CITY OF ALBUQUERQUE

May 7, 2024

Re: Blake's Lotaburger
641 Coors Blvd. NW
Traffic Circulation Layout
Architect's Stamp 03-14-24 (J10-D052)

A2 ARCHITECTURAL SITE PLAN
1" = 20'-0"

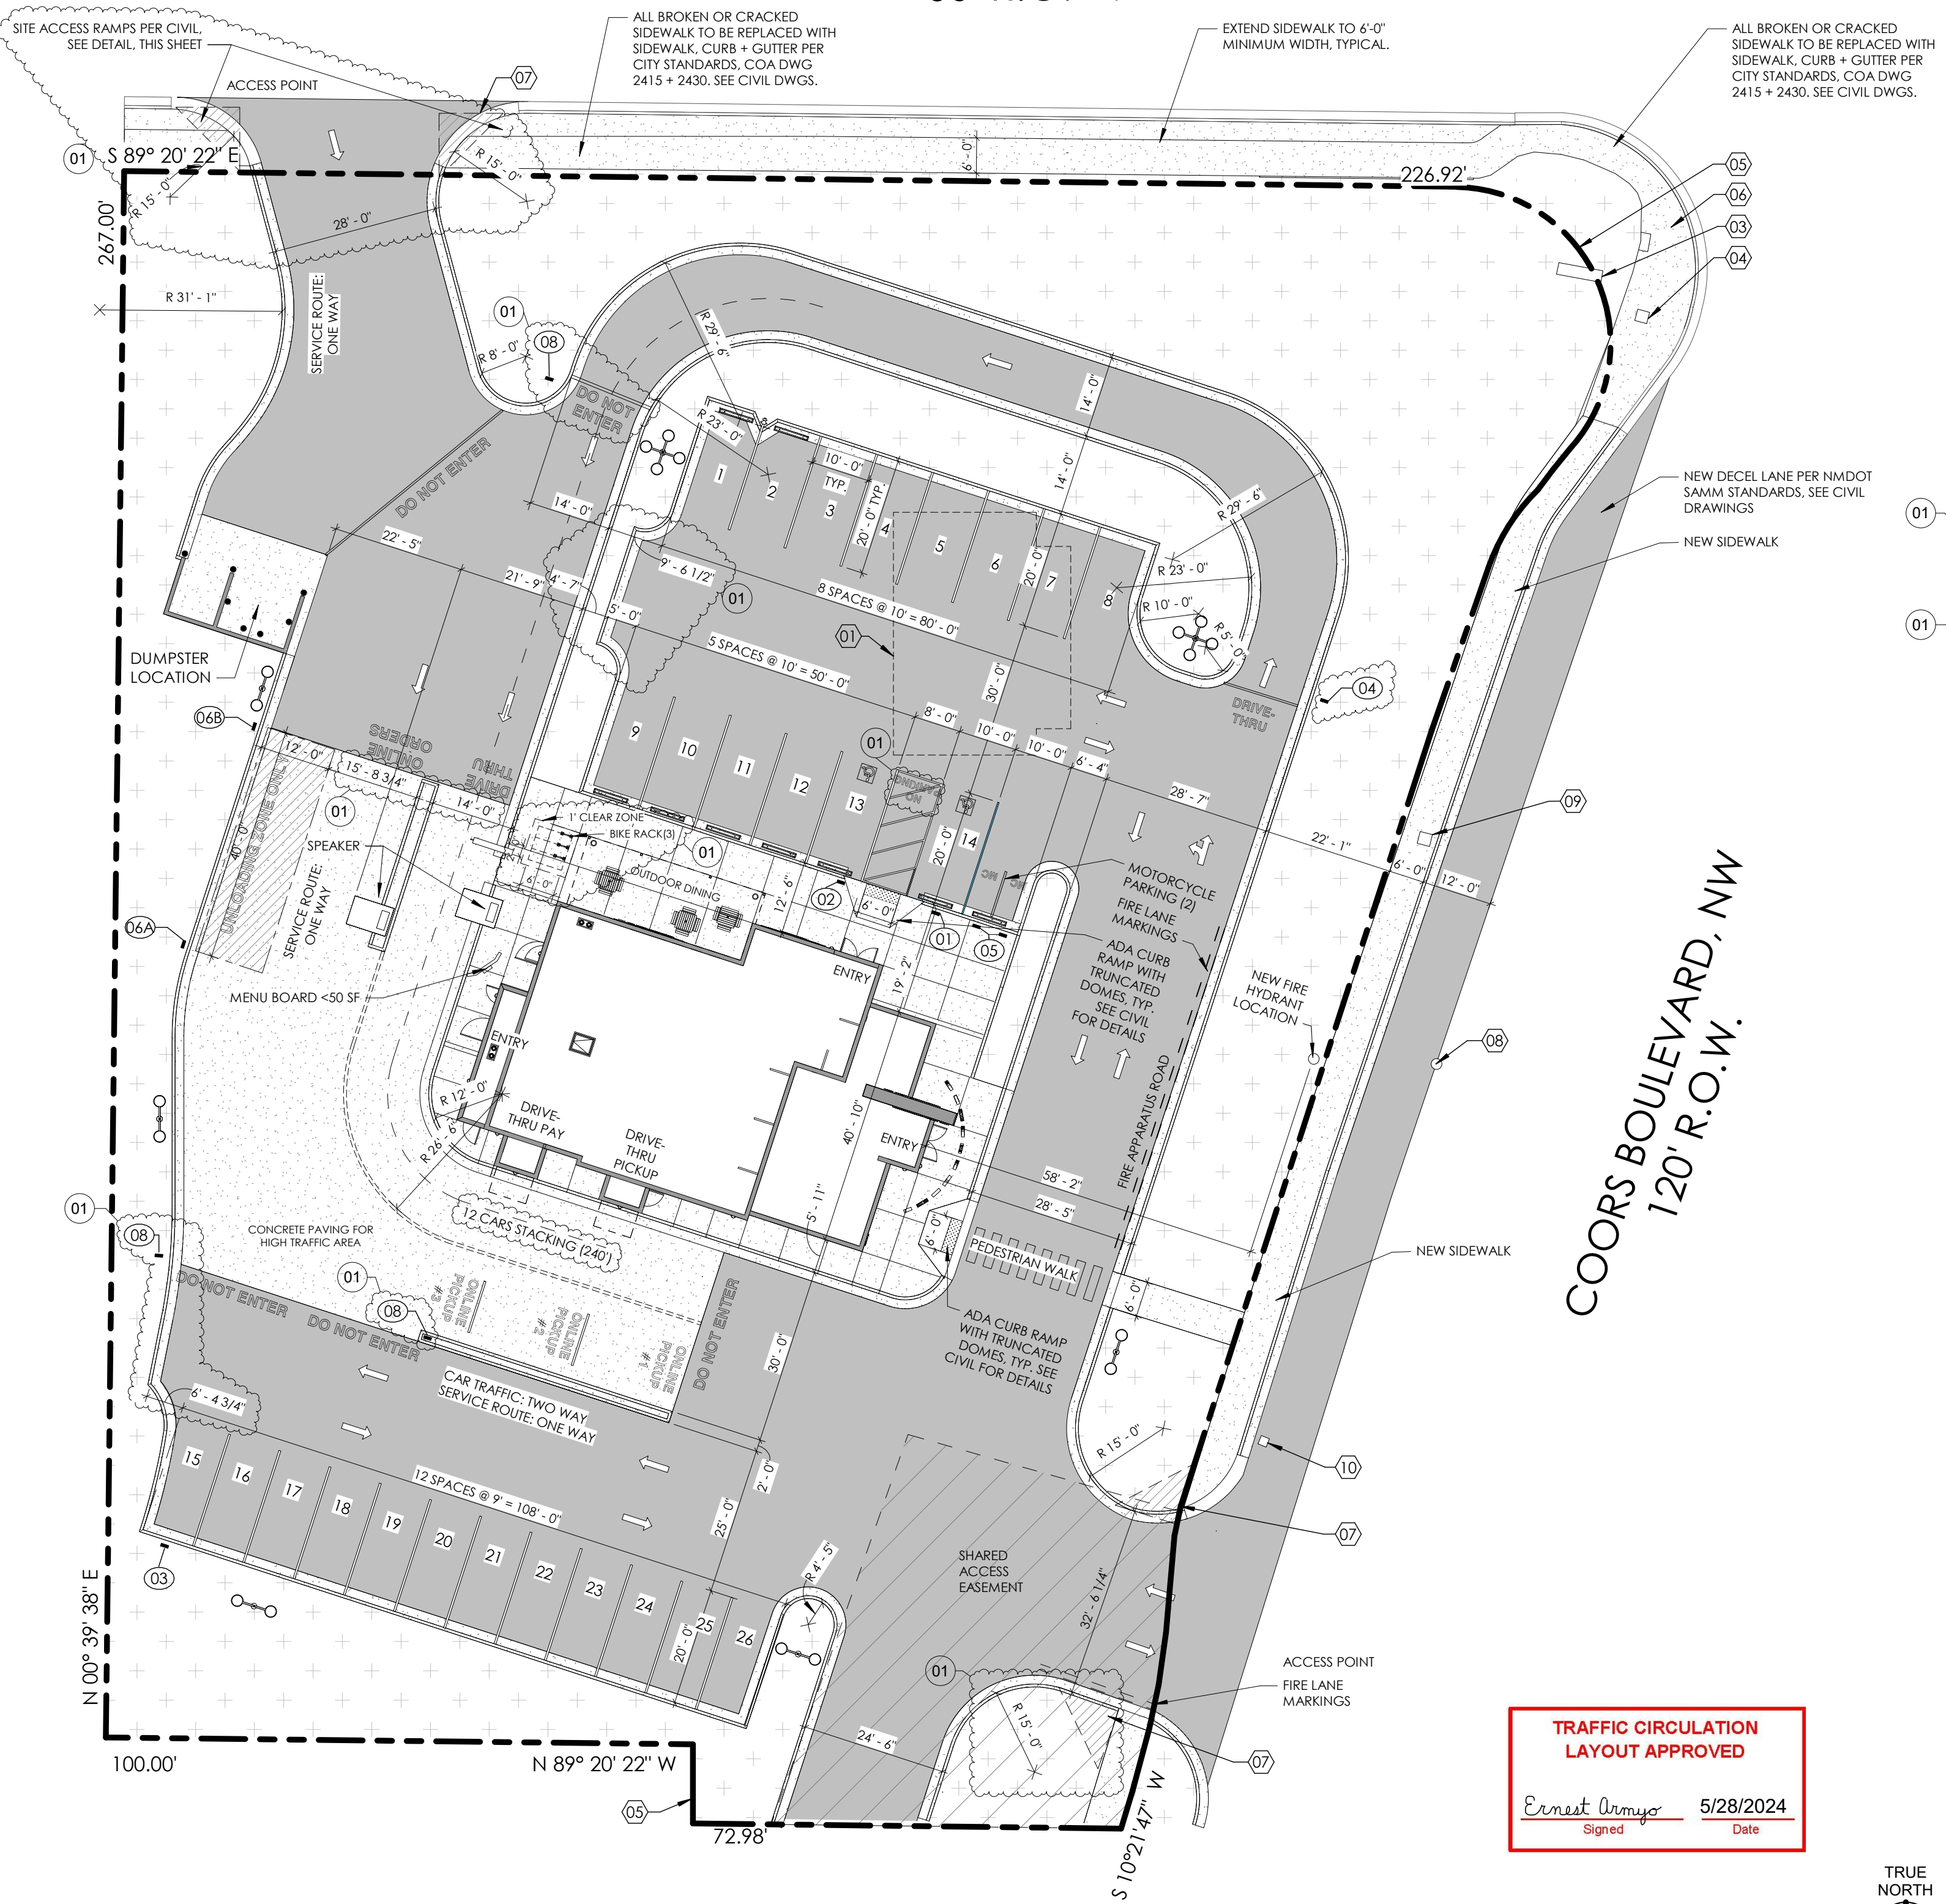
1. The proposed site access, sidewalk, and the right turn lane improvements off Coors Blvd.: NMDOT Approval is required prior to approved the TCL.
2. Please show on the site plan both site accesses width and radii.

3. Please provide copy of shared access easement approval.
4. Site access off Fortuna Rd: please provide site access ramps details and reference city std dwg.
5. The ADA access aisles shall have the words **"NO PARKING"** in capital letters, each of which shall be at least one foot high and at least two inches wide, placed at the rear of the parking space so as to be close to where an adjacent vehicle's rear tire would be placed. (66-1-4.1. B NMSA 1978)

6. Please show on the site plan each drive-thru lane width.

7. Please specify the number of vehicles stacking in the drive-thru lane on the site plan.
8. "DO NOT ENTER", "STOP" and "ONE WAY" signage must be provided for all proposed one-way drive lanes.

9. Keynote 7: please show the clear sight triangle for the site access off Coors Blvd. at the back of the sidewalk.

10. All bicycle racks shall be designed according to the following guidelines:
- The rack shall be a minimum 30 inches tall and 18 inches wide.
 - The bicycle frame shall be supported horizontally at two or more places. Comb/toaster racks are not allowed.

- 11. Bicycle racks shall be sturdy and anchored to a concrete pad.
 - 12. A 1-foot clear zone around the bicycle parking stall shall be provided.
 - 13. Bicycle parking spaces shall be at least 6 feet long and 2 feet wide.

- 14. A 5 ft. keyway is required for dead-end parking aisles. Per the IDO, a 6 ft. wide ADA
 - 15. Provide copy of Fire Marshal and Solid Waste approval.
